DRB Application No.: 03-00996 (SBP)
Project Name: JOURNAL CENTER PHASE 2
Agent: Tate Fishburn Architect

Re: Journal Center Phase 2: Architectural Review Committee Report
Revised drawings for Lots 16-19

CITY OF ALBUQUERQUE
Planning Department
Development Review Board
June 25, 2003 Comments

Project Name: Journal Center Phase³ Lots 16-19

DATE: JUNE 17, 2003
 SCALE: 1"=30'-0"
 DRAWING NAME: SITE DEVELOPMENT PLAN
 SHEET NUMBER: SDP-1

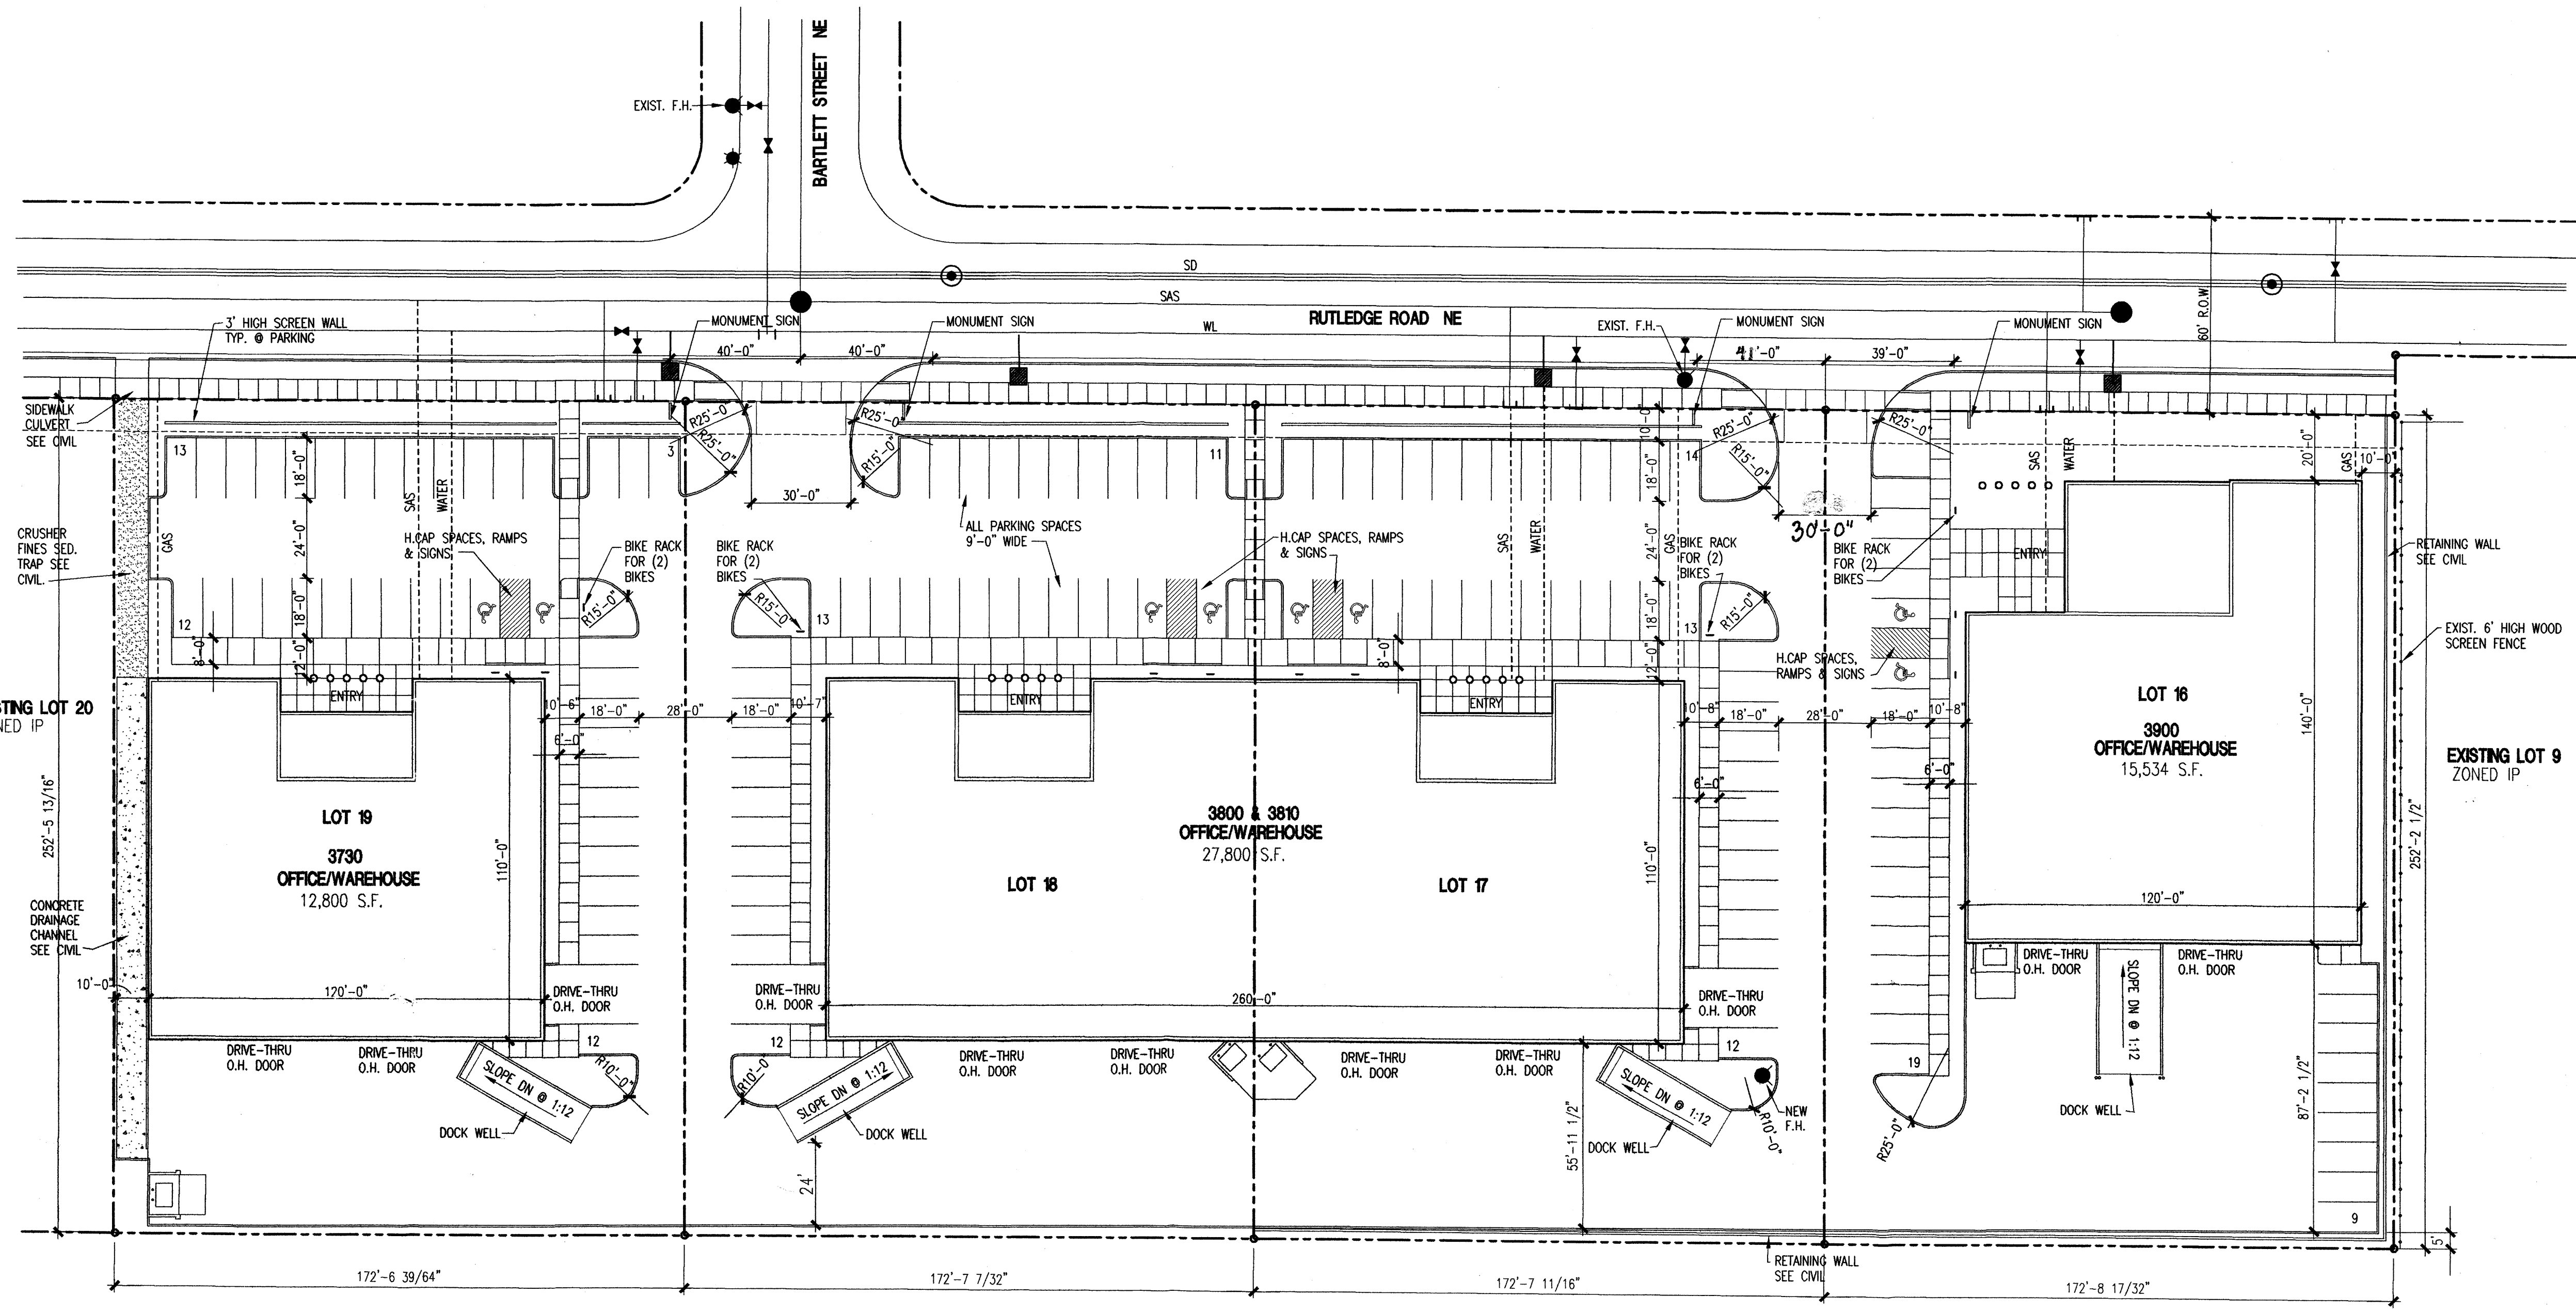
- TRANSPORTATION: Cross Access Easements, Site conforms w/ T15, Increase EAST DRIVEWAY to 30' in width.
 -
 -
 -
 -
- UTILITIES: _____
 -
 -
 -
 -
- CITY ENGINEER / AMAFCA: _____
 -
 -
 -
 -
- PARKS / CIP: _____
 -
 -
 -
 -

The Site Plan for Building Permit sheet must have the Journal Center Master Plan signature block with the addition of the other DRB members signature lines. It must also be labeled "Site Development Plan for Building Permit".

SDP-4

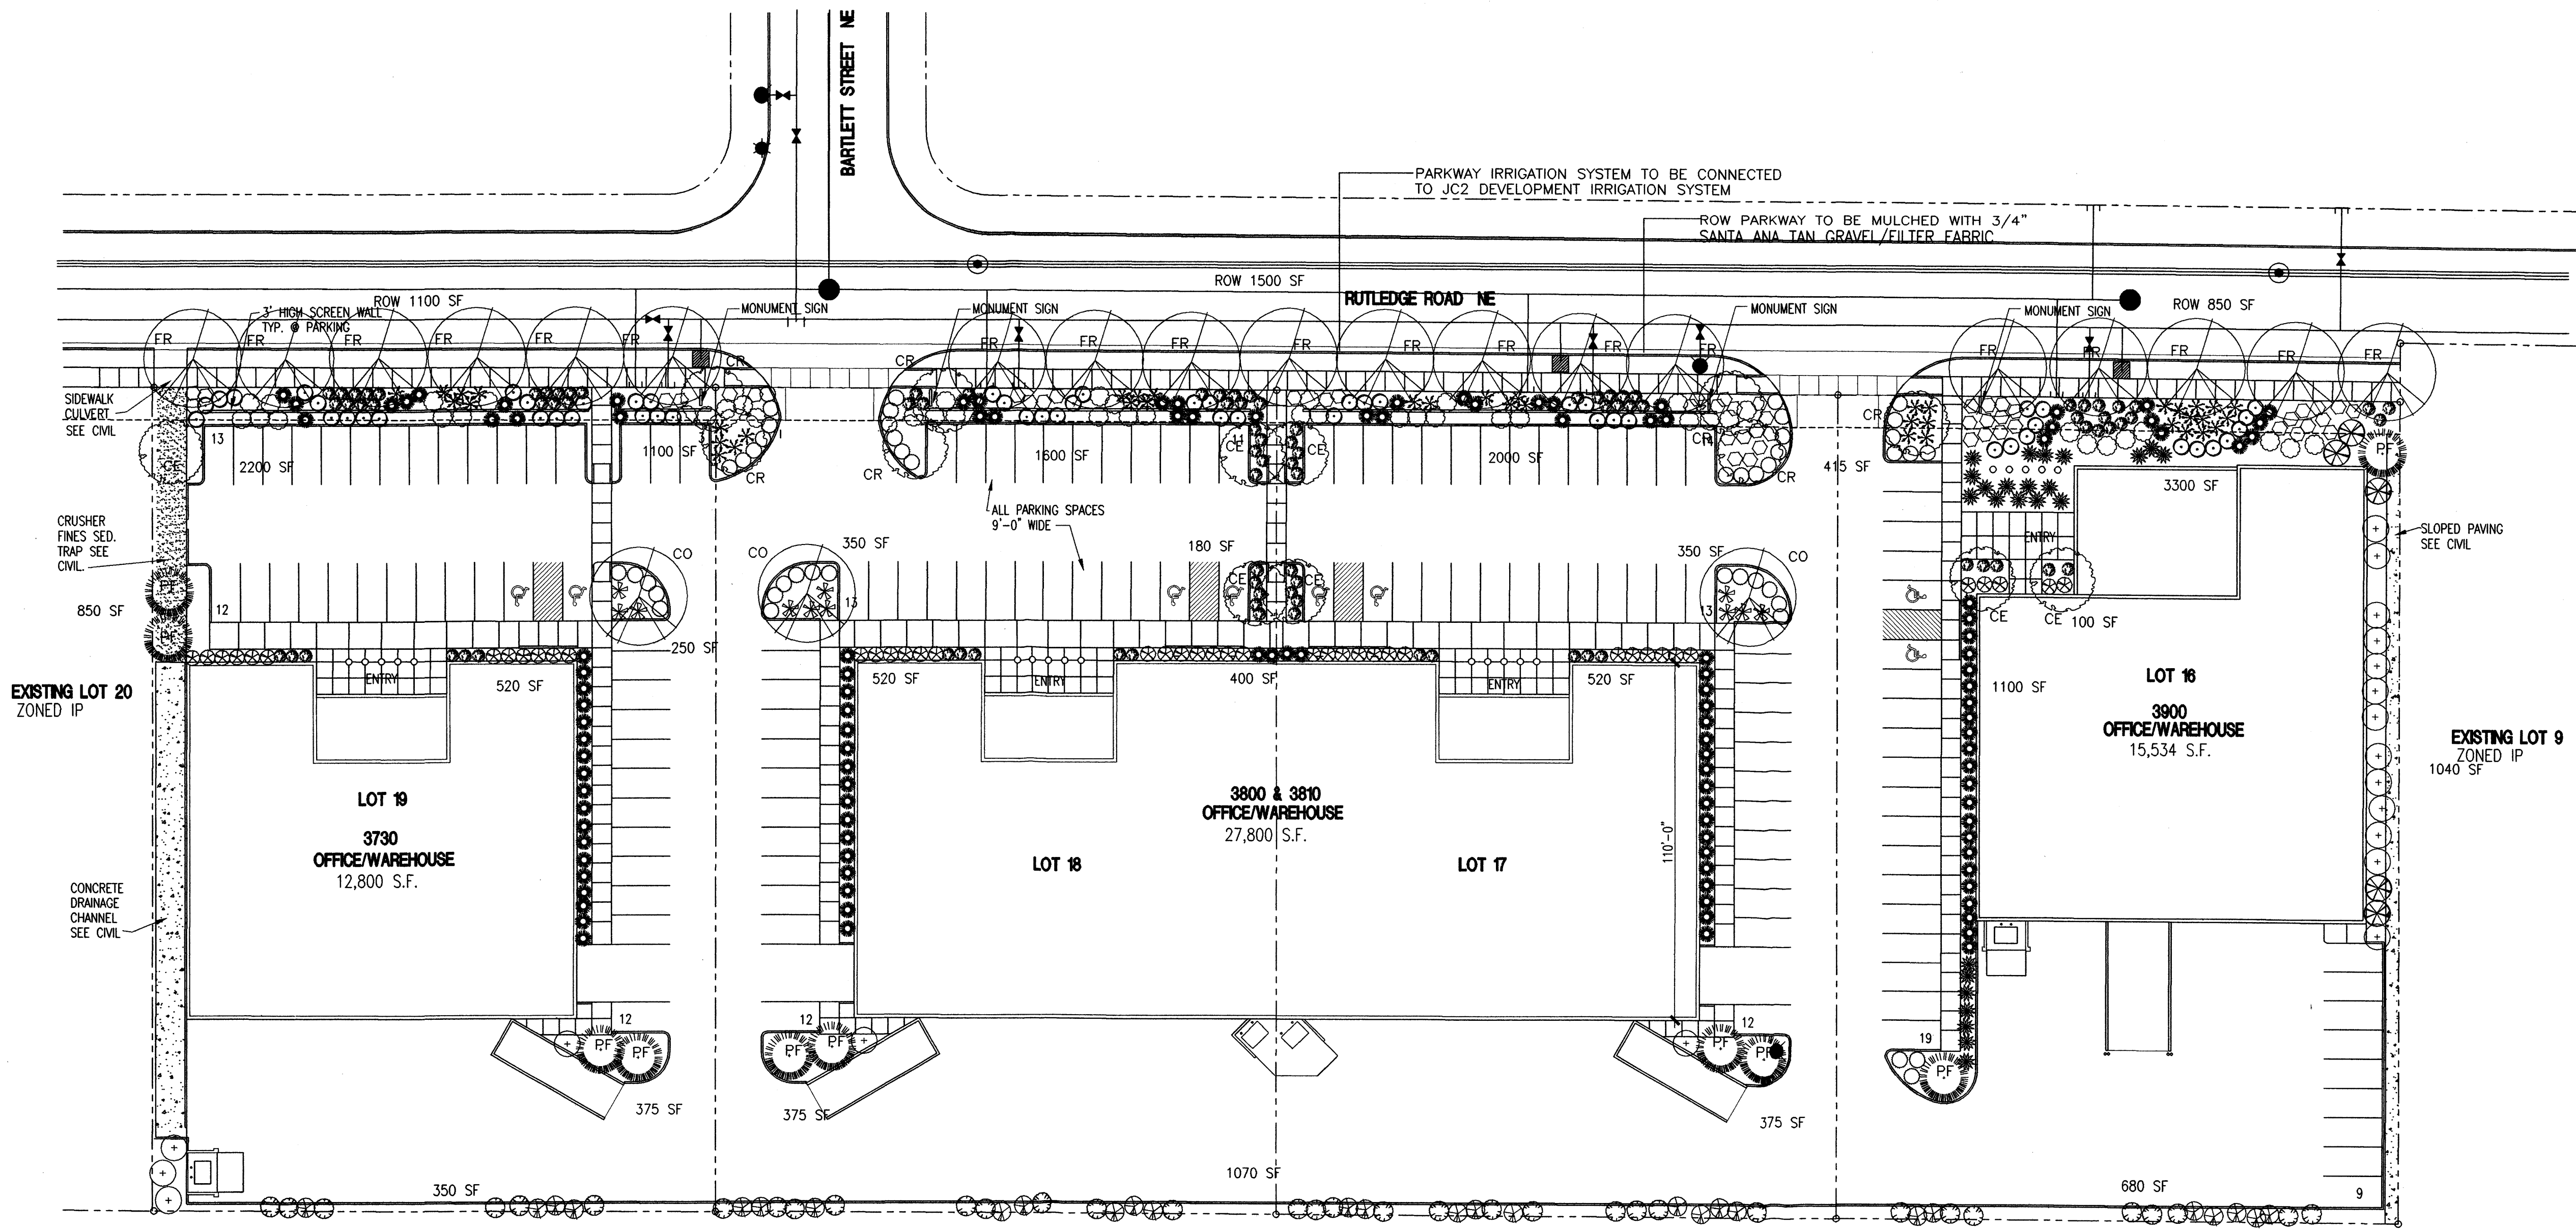
The trees selected for use are high water use. The City strongly encourages the use of trees or other vegetation which require less water.

SITE DEVELOPMENT PLAN FOR
INDUSTRIAL PARK @ JOURNAL CENTER 2
LOTS 16-19, JOURNAL CENTER 2
ALBUQUERQUE, NEW MEXICO

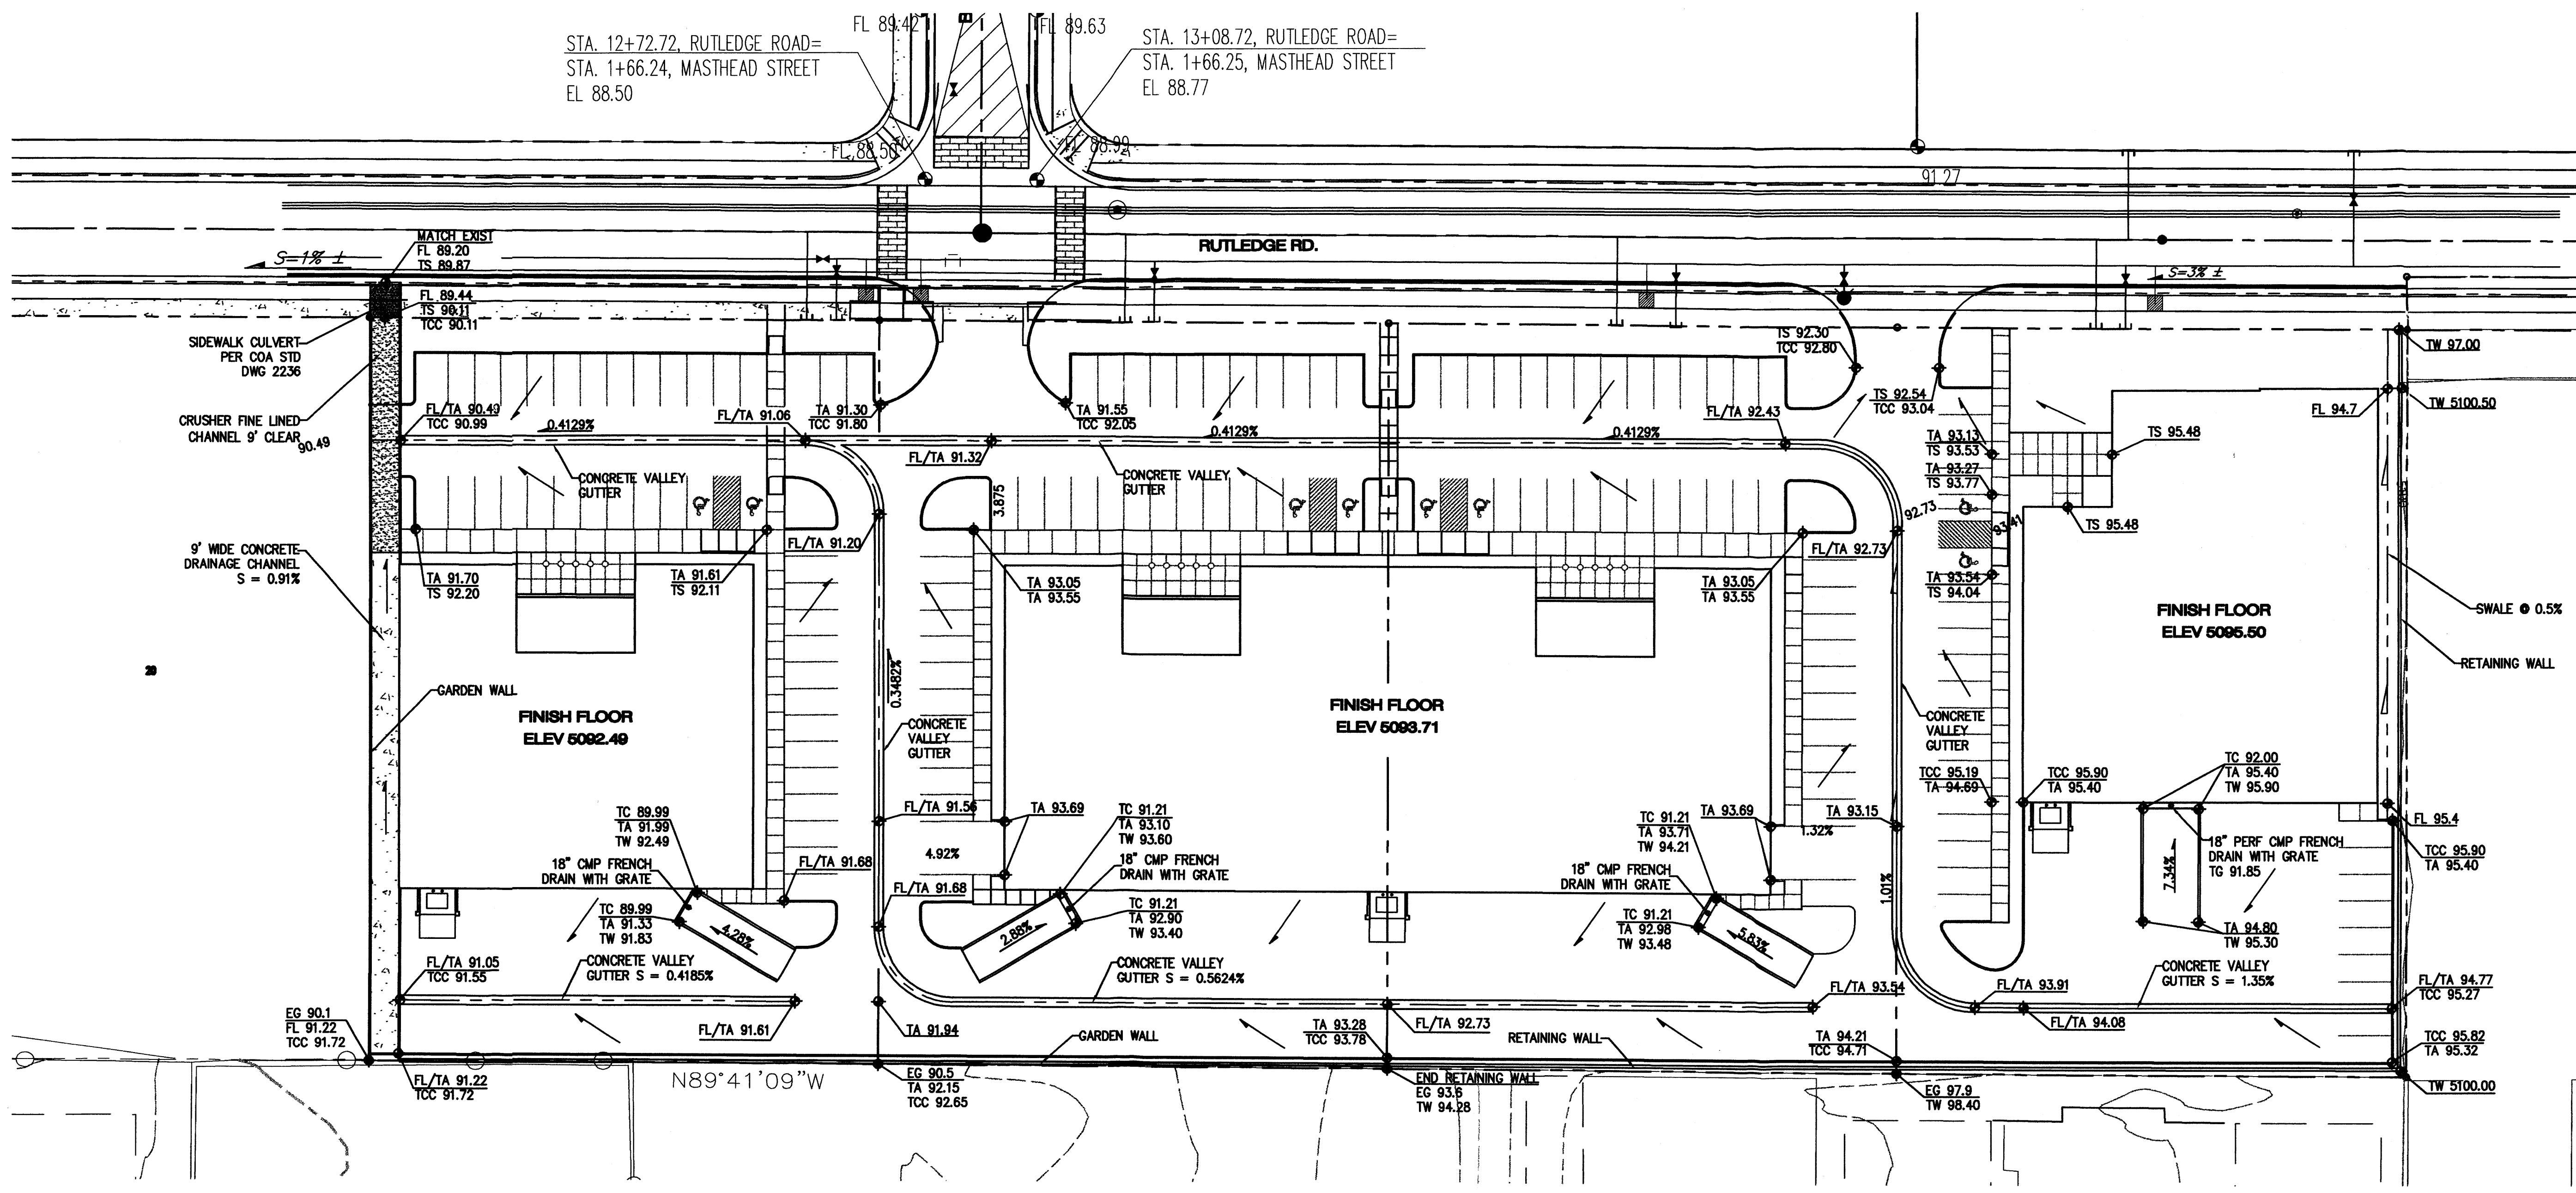
1. The note referring to a trash rack has been removed from the Conceptual Grading and Drainage Plan, yet the typical trash rack detail from the JC2 Design Guidelines has been added. As stated in our previous letter, this device is not required and should not be used on this project.

2. The fire hydrant and water meter that are to be installed as part of the development infrastructure currently under construction are still shown in the two drive pads on the Conceptual Grading Plan. These devices will need to be located in the landscape area outside of the drive pads.

3. The pedestrian crossings at the two drive pads must have a maximum cross slope of 2%. This should be noted on the final grading plan.
4. The 3' screen wall for the parking area along Rutledge Road is not shown on the Conceptual Grading Plan, but is shown on the Site Plan and Landscaping Plan. The final grading plan should indicate this wall and incorporate it into the grading solution.

Your submittal is approved based on the submitted drawings and the conditions of approval listed above. These conditions shall be incorporated in to the final grading and drainage plan and in the project's construction. We will forward the plans to the Journal Center for their review and subsequent issuance of a letter of approval to the DRB.
